From: Anita Gardner
Sent: 03 September 2018 08:55
To: Planning.Responses
Subject: FW: EG/52/18/DOC - Application for approval of details reserved by condition imposed on planning permission EG/22/17/PL relating to condition 4 - Details of Construction

Mr Peter Hake
Project; Gravel driveway
Stoneyfield Nursery PO20 3SL
17/7/18

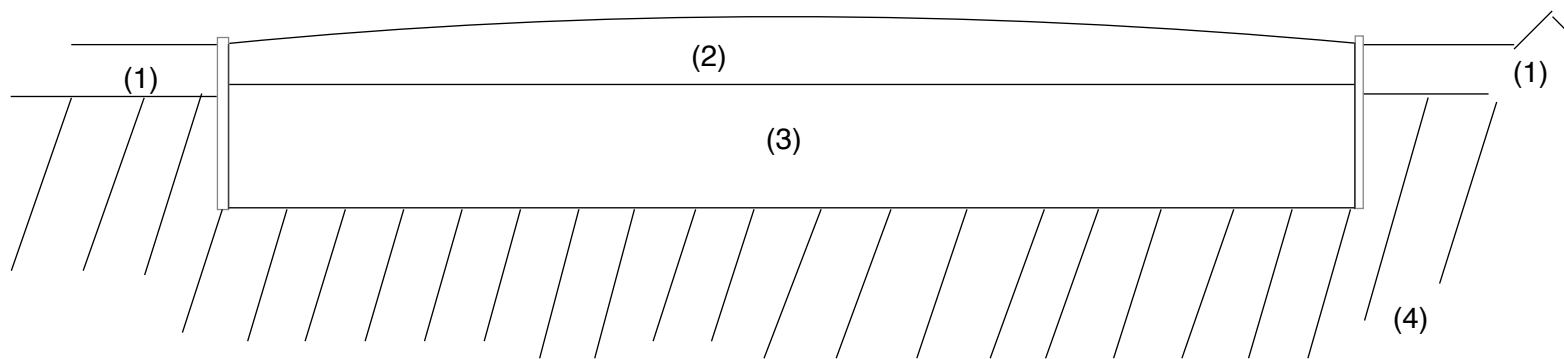
I have received the above application which contains a plan with very little detail. I would appreciate clarification as to whether it is a cross section or floor plan, together with the scale and where nos 5-8 (referred to in the Notes) are located.

The drawing is an indicative cross section but not to scale.

Note 5 draws attention to detail 3 on the drawing which is clean crushed hardcore to a depth of 400mm.

Note 6 refers to item 2 on the drawing which is a top surface of MOT type 1 rolled to 200mm thick.

Note 7 states that the width of the road will be 3.25 metres.

Note 8; States that a 6" timber edge will be installed along the whole road.

Stoneyfield Nursery new drive.
Detail of junction to Eastergate Lane
Ref; EG/22/17/PL

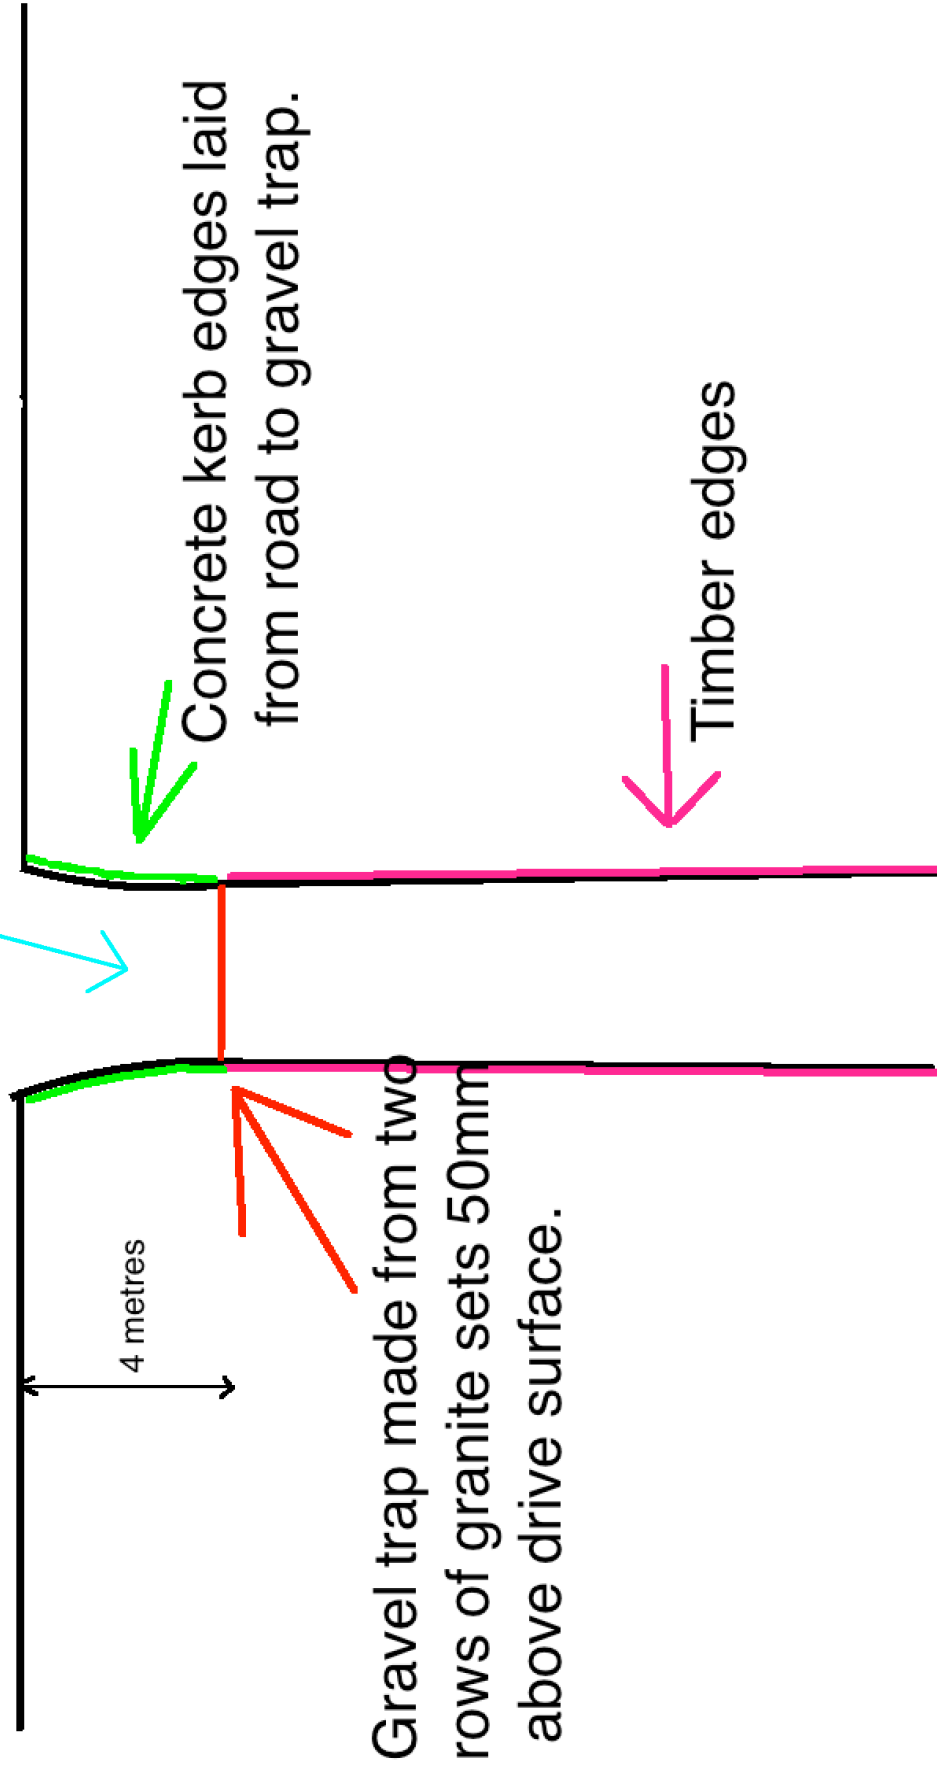
Further to your client's response below I would appreciate a layout/block plan to indicate the position and extent of the proposed timber edge to ensure that it does not encroach onto the highway.

I enclose two diagrams. One is a plan of the position of the driveway. The second shows detail where it meets the road.

I can confirm that the timber edge will stop 4 metres before the road and then will then continue in concrete kerb.

The gravel trap will be fabricated by two rows of granite sets laid 4 metres from the road and raised 50mm from the surface.

Tarmac will be laid beyond the gravel trap.
